Application for a non-material amendment following a grant of planning permission.  
Town and Country Planning Act 1990

Erection of 80no. dwellings with associated works (revised description 16/11/2021)

DM/20/02681/FPA

Amendment to be made due to the necessary addition of a substation to the layout.

Date: 17:08:20 Drawing No: GH100: L: 04 J

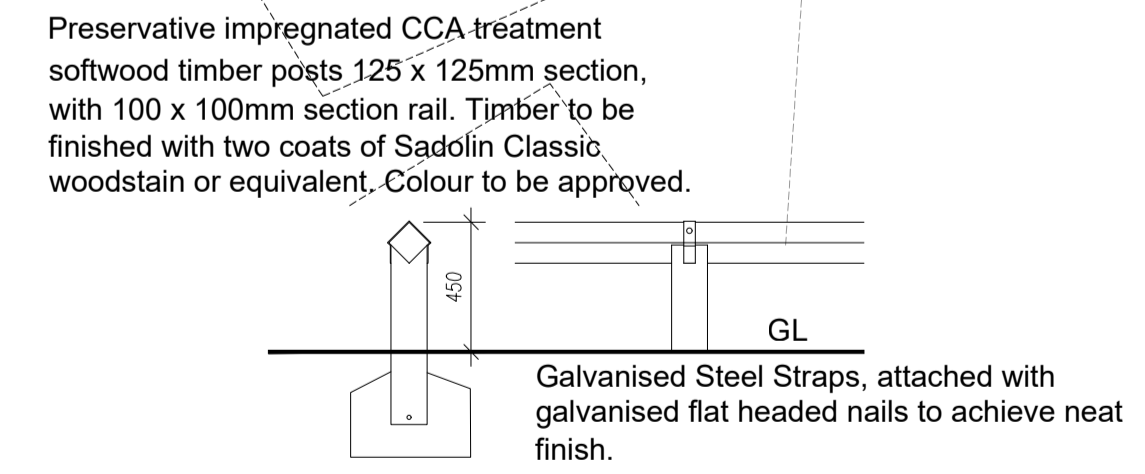
Approved Boundary Treatment Layout 'GH100:L:04 F' to be replaced with Boundary Treatment 'GH100:L:04 J'

The amendment is needed due to the necessary addition of a substation adjacent to plots 5 and 6. This has resulted in the removal of a side garage and a change of house type of plots 5 and 6.
